Vattenfall Norfolk Vanguard Offshore Wind Farm

Necton Substation site

I am writing to you in my capacity as Chairman of Little Dunham Parish Council.

Drawing file: EN010079 / EN010079-001897-Figure 29.09 Indicative Onshore Project Substation Mitigation Planting.pdf

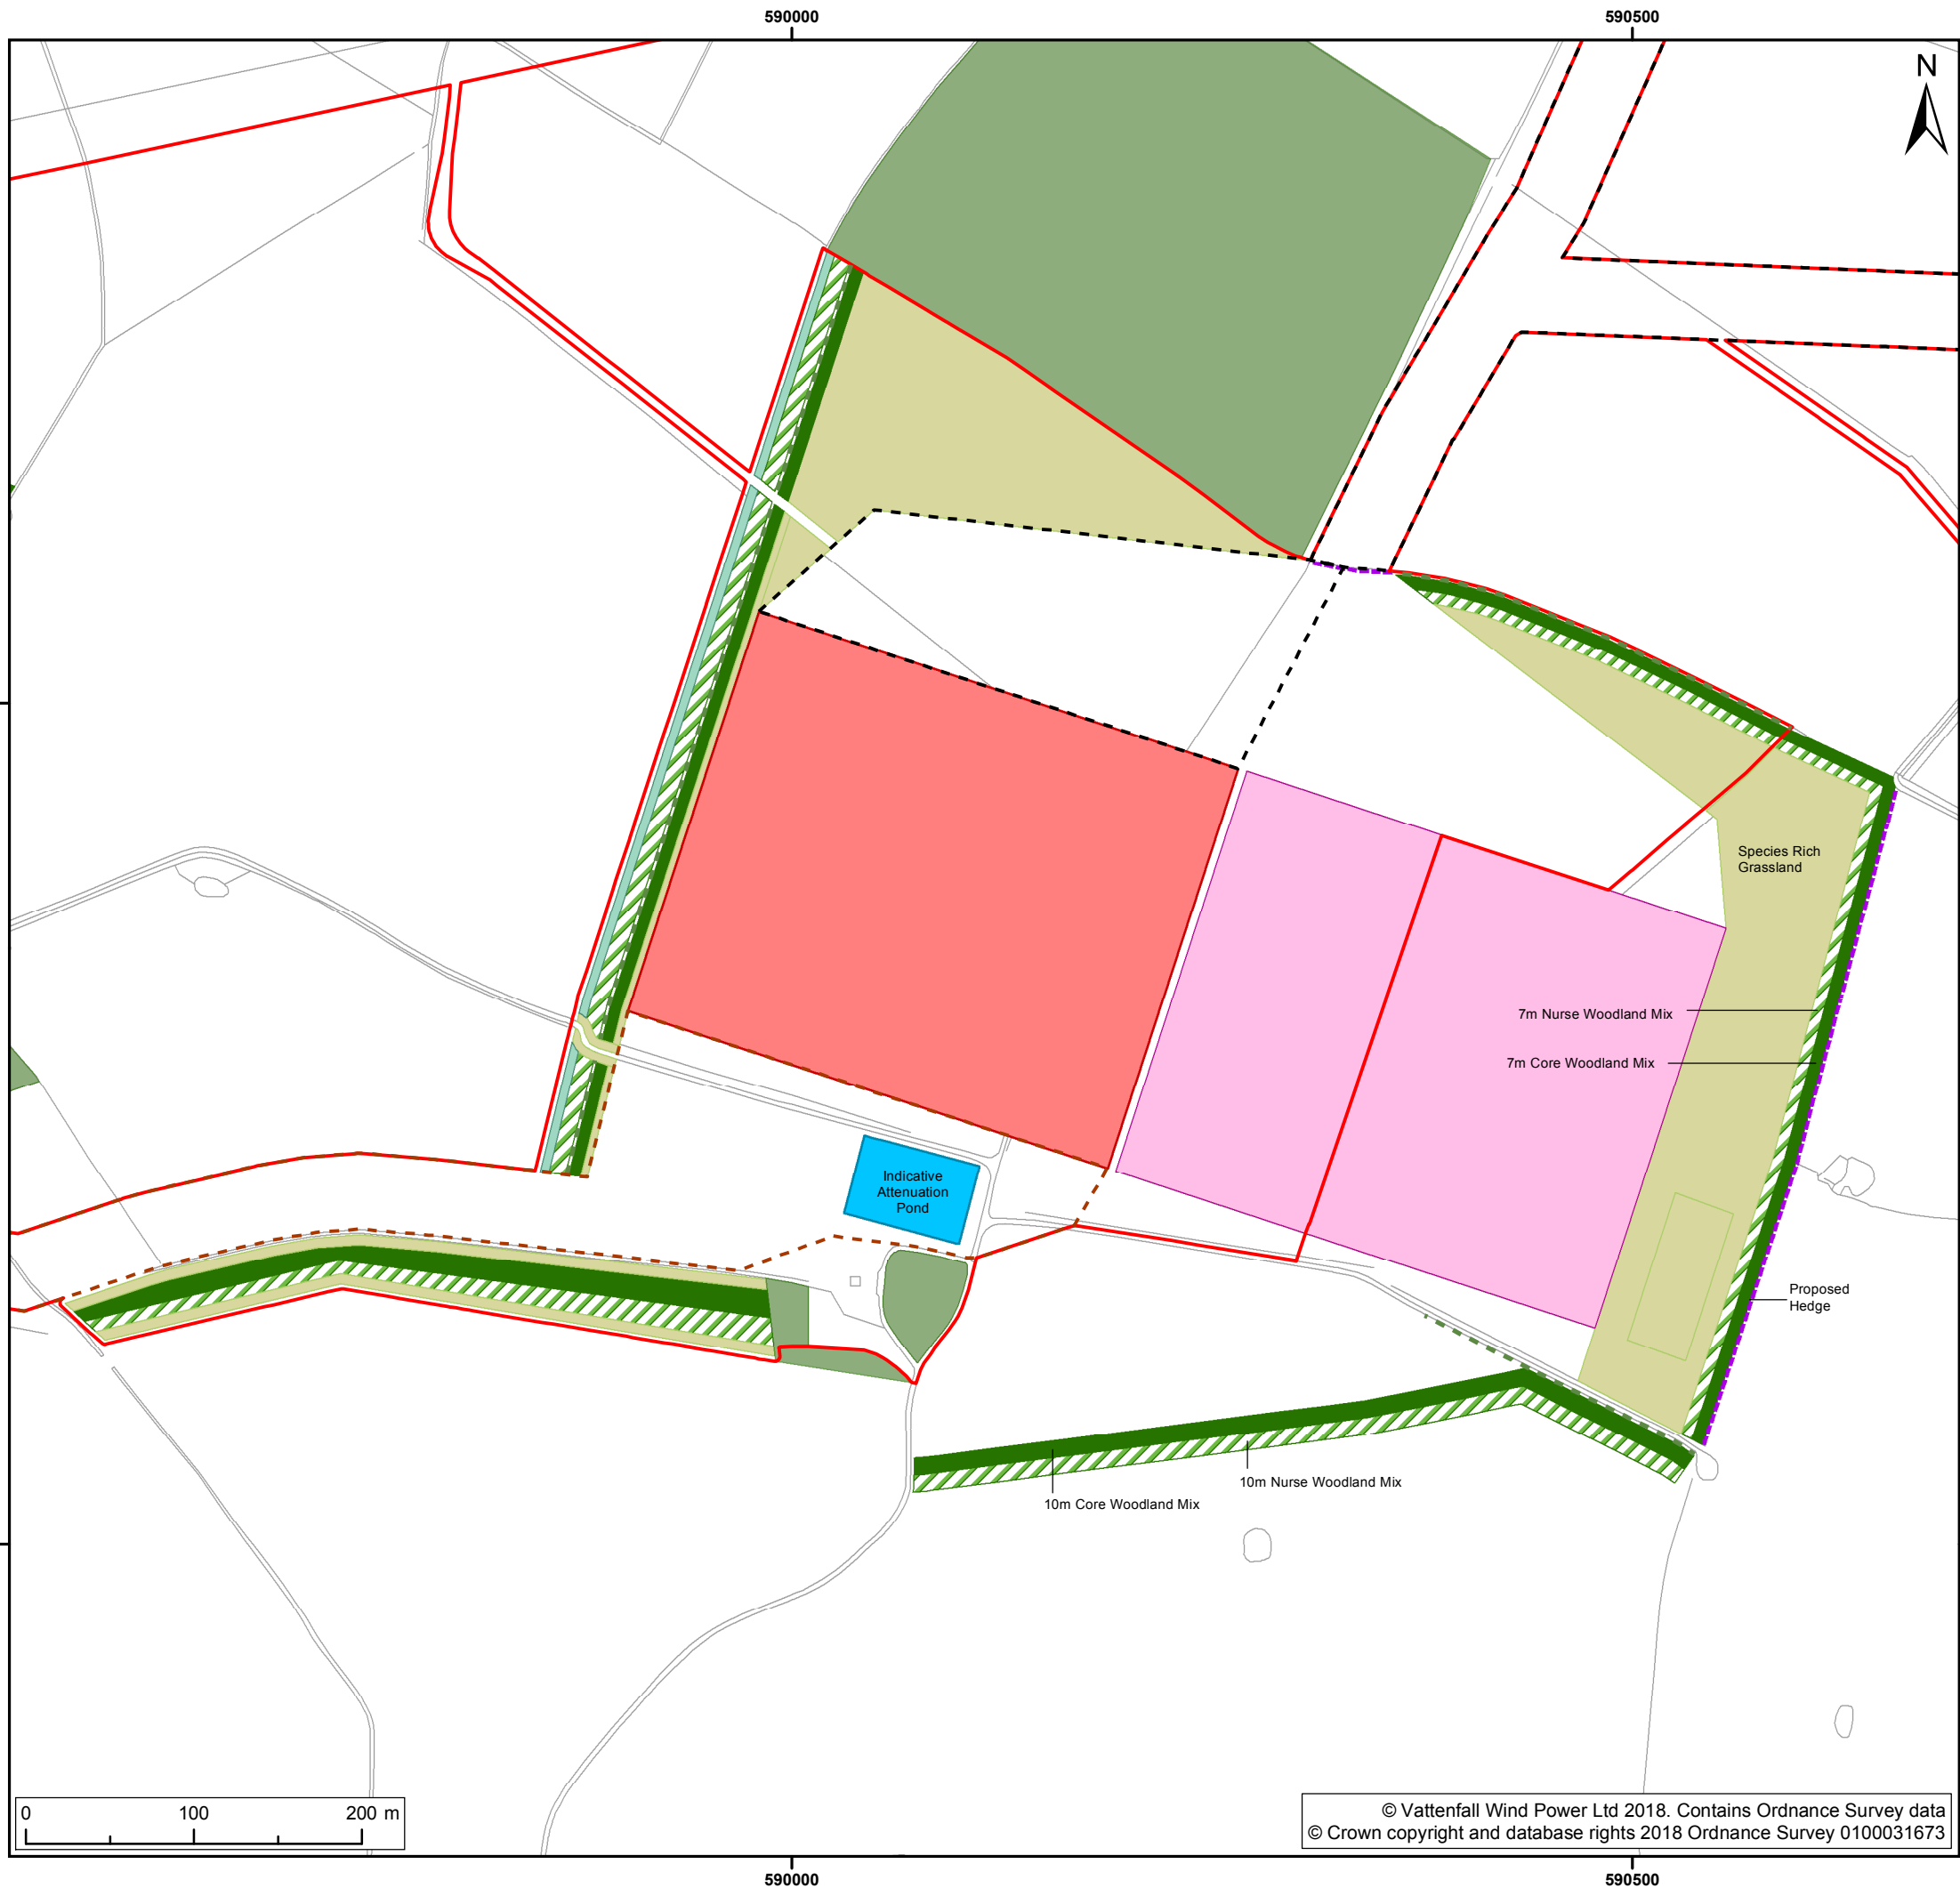
We acknowledge that the construction of bunds and the subsequent planting of trees will for five months in a year ameliorate the landscape and visual impacts of the large scale industrial development that is being proposed. However if the development is allowed to proceed with DC transmission then no amount of mitigation will conceal in full or in part the four buildings which will house the transformers that will be required before the supply can be connected to the National Grid.

The key characteristic of the landscape in the area the subject of this application is an open flat plateau. Paragraph 8.15 would suggest that the additional construction of large bunds would severely alter the landscape and the construction of such bunds would in any event fail to screen the four transformer buildings.

We would ask the Inspector to consider this point carefully and place a condition on any approval that the permission should be for AC transmission only. This would, we feel, go some way towards the mitigation of the impact of such a large scale development in a remote and scenic area.
